**Re: Objection to MP08\_0244 MOD 1 Modification Request for Mixed Used Development at 23-37 Lindfield Avenue and 11 Havilah Lane, Lindfield**

1 HAVILAH LA ELEVATION
2001 SCALE1 : 250

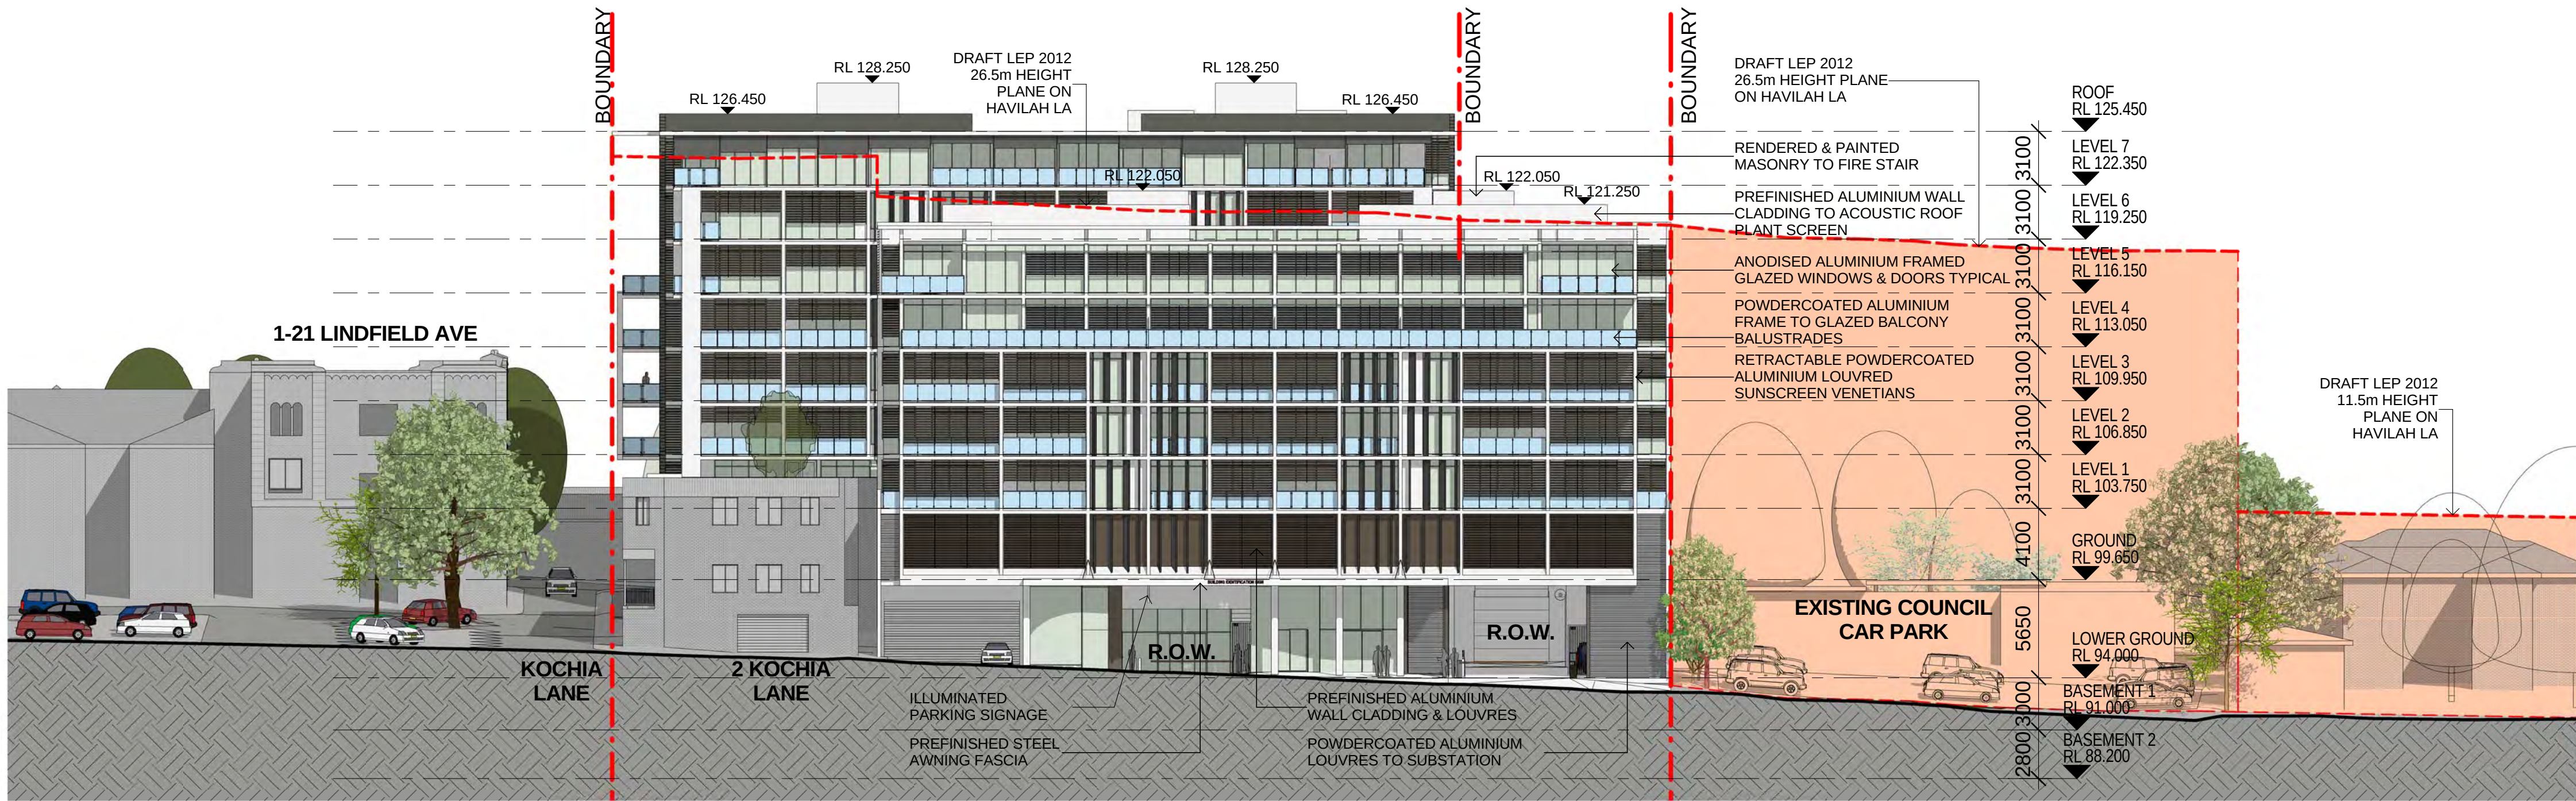
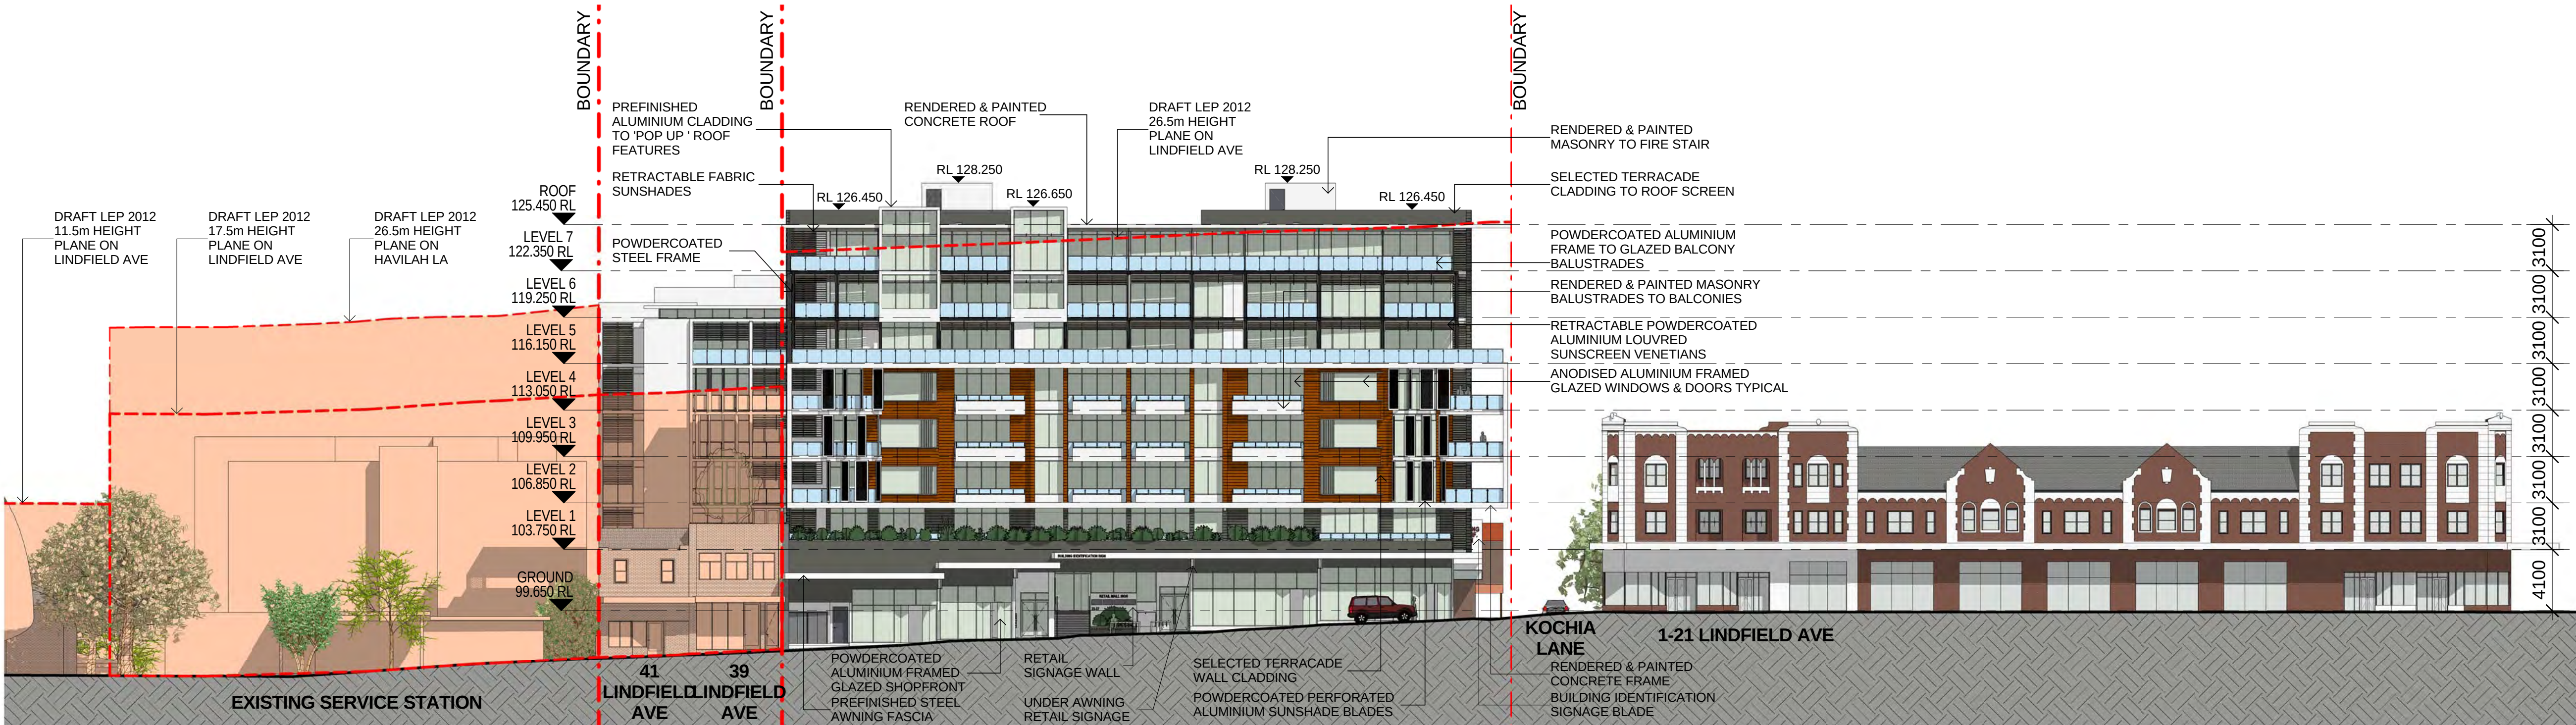
- The increase of an additional storey to both buildings: 8 storeys on Lindfield Avenue and 7 storeys on Havilah Lane creates excessive height and bulk and is out of character with the surrounding buildings, including the heritage listed adjacent building on Lindfield Avenue

1 SHADOW DIAGRAM - 21stDEC_9AM
5003 SCALE1 : 650

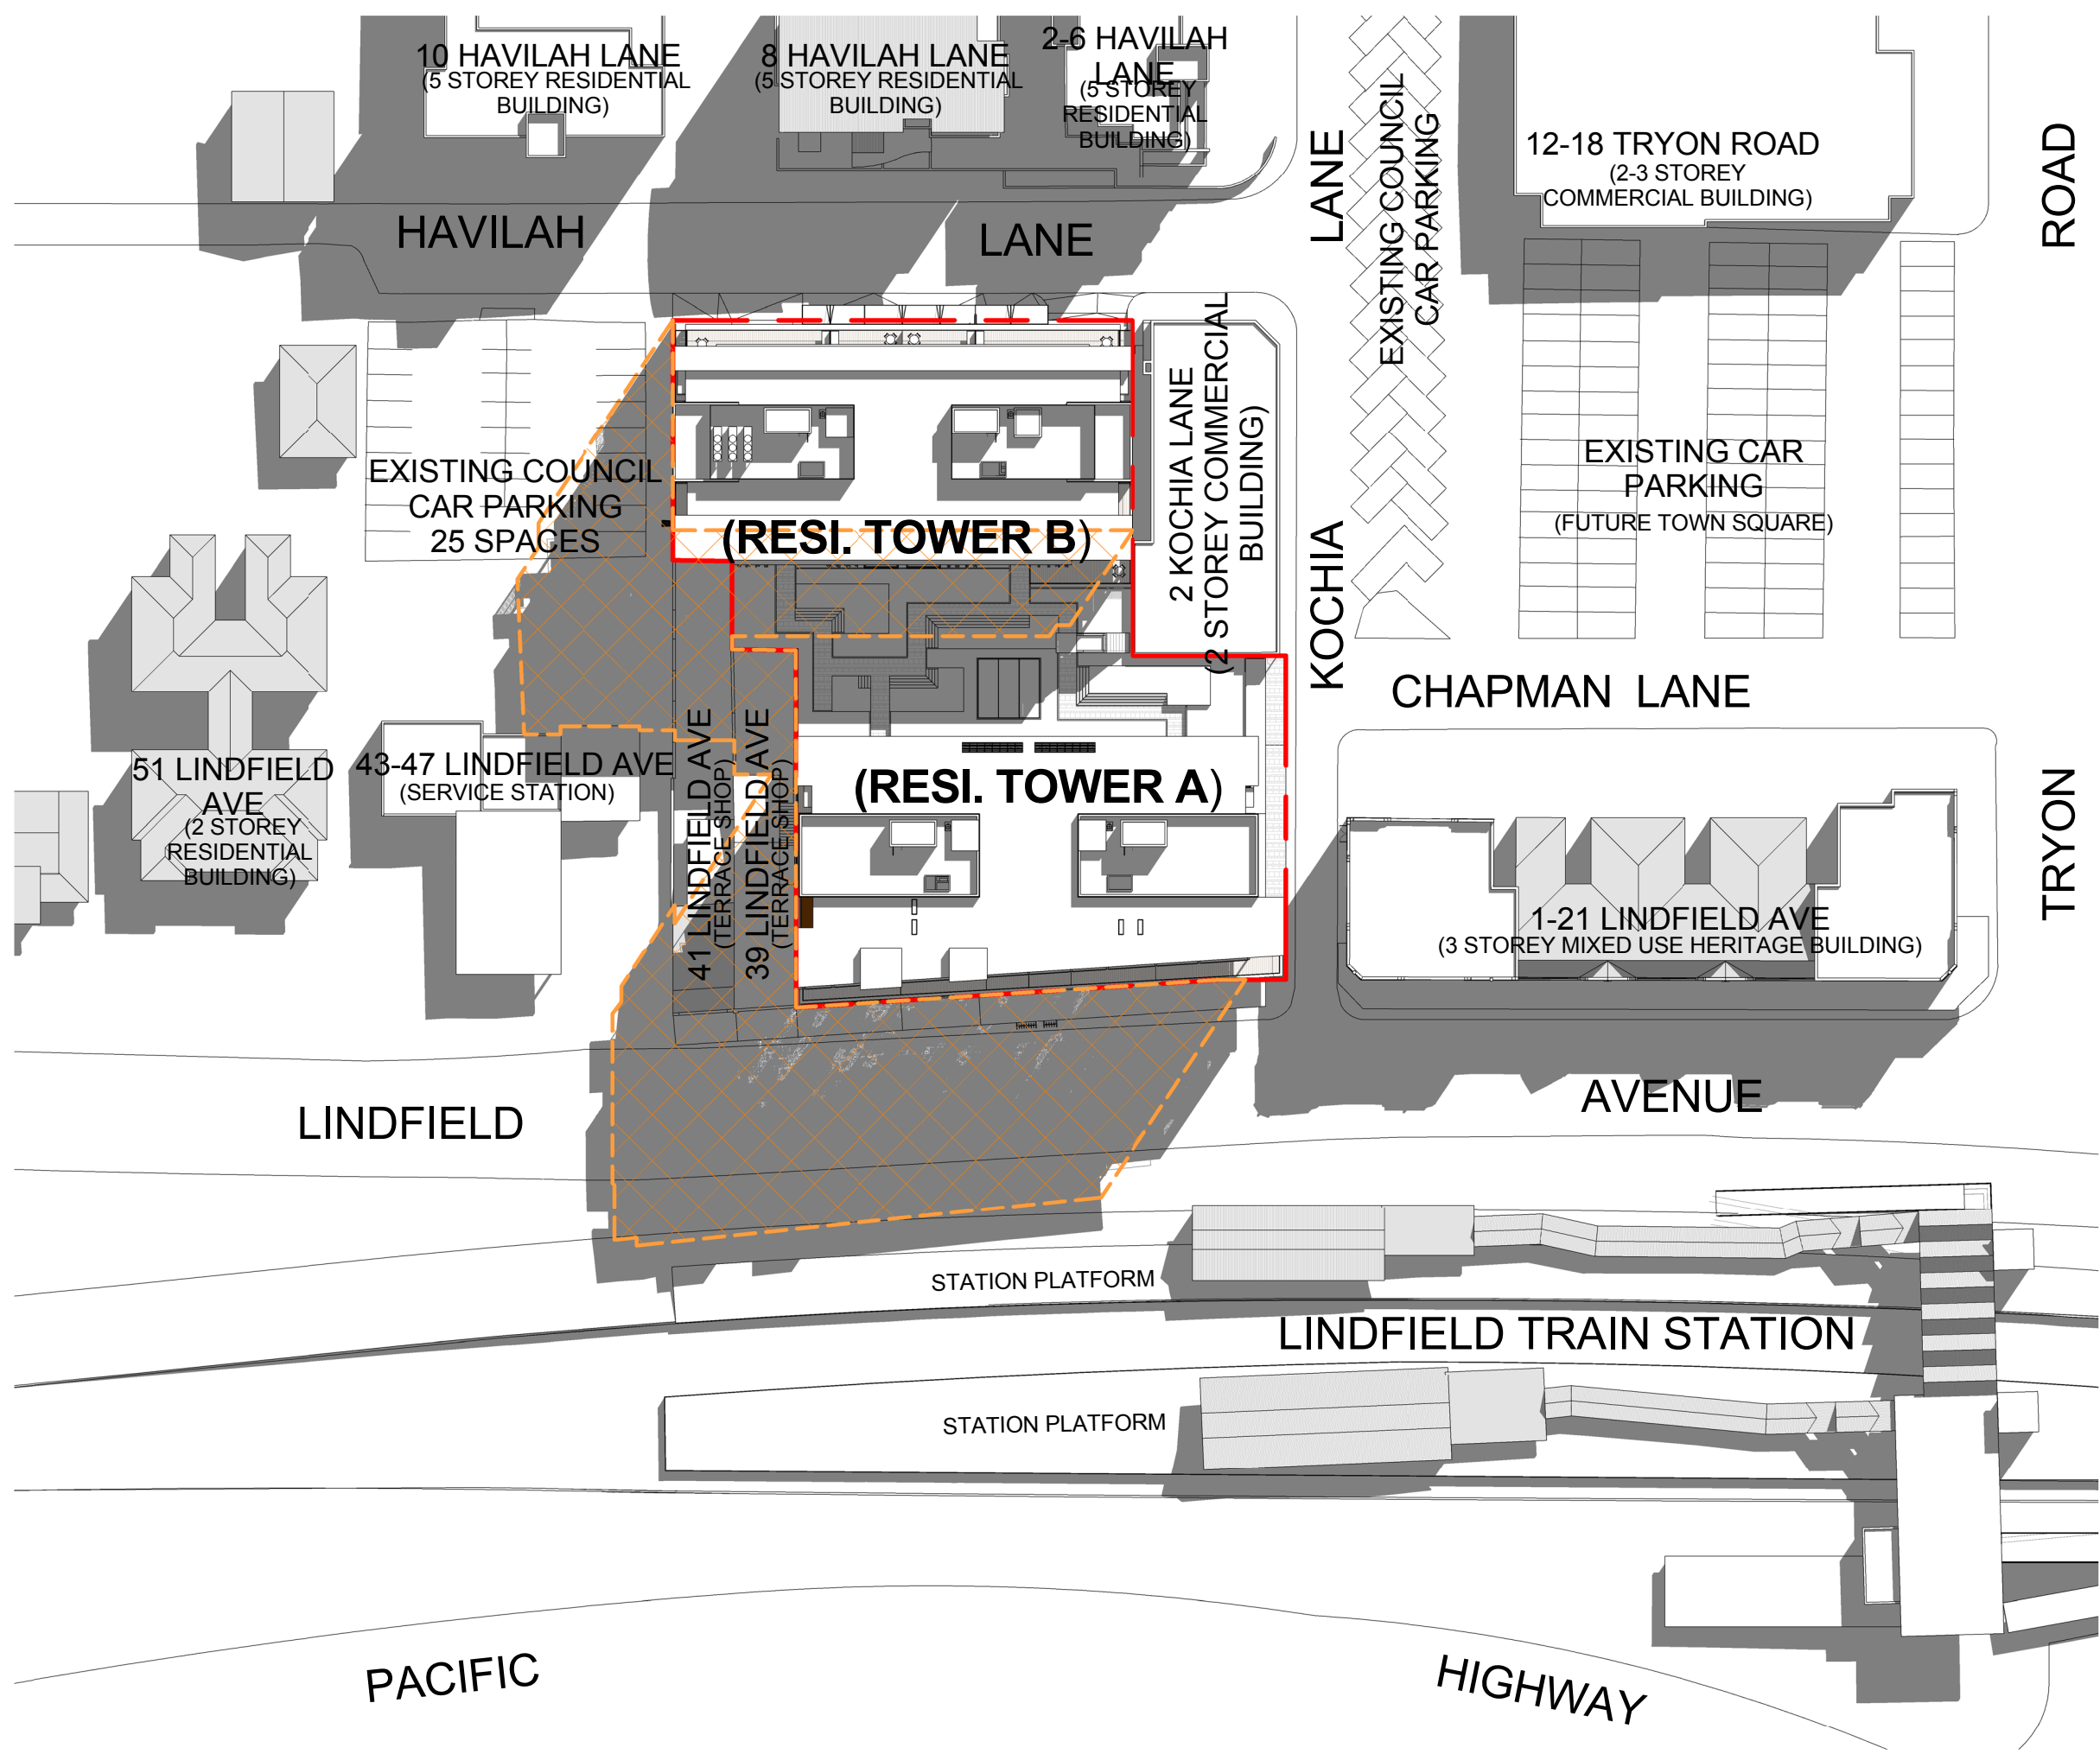
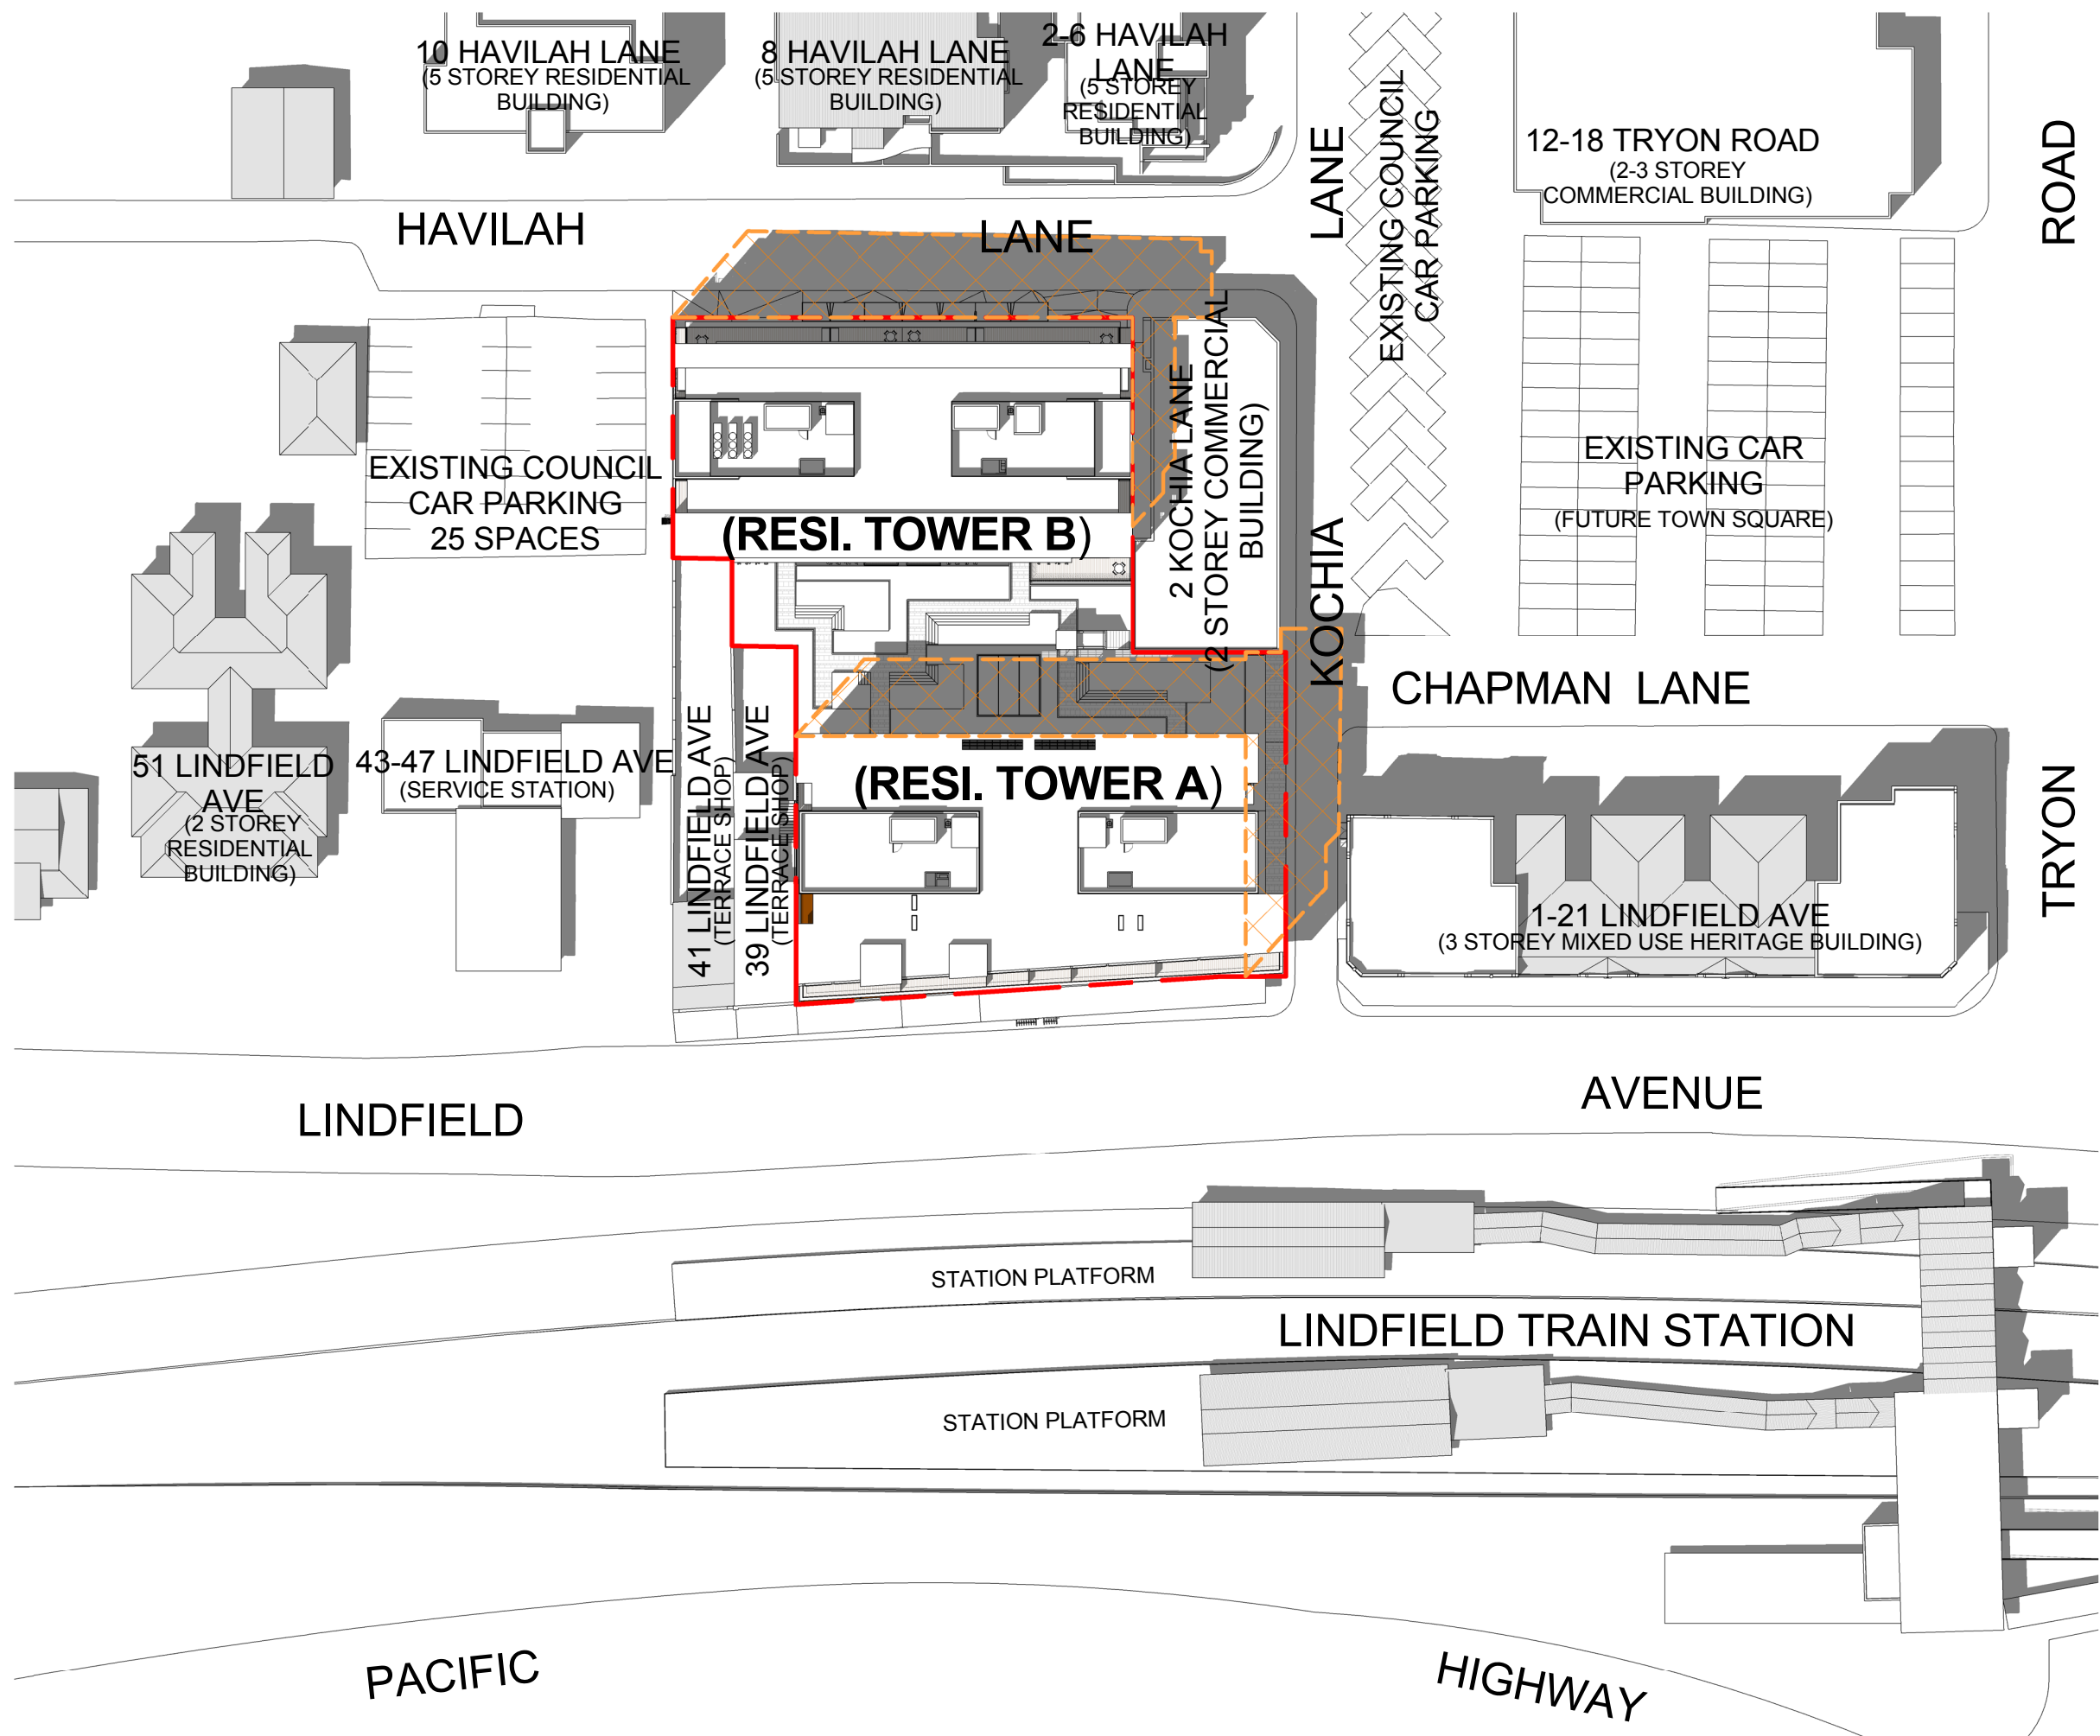
- The additional storeys create new adverse shadowing: a) for residents in the Havilah Lane apartments, particularly after 3pm b) for the popular outdoor café and central Lindfield hub area at 12 Tryon Road in afternoons, particularly in winter and c) for all commuters on the city bound Lindfield rail platform, instead of 50% of the year as approved, it will now be in shadow in the mornings 75% of the year
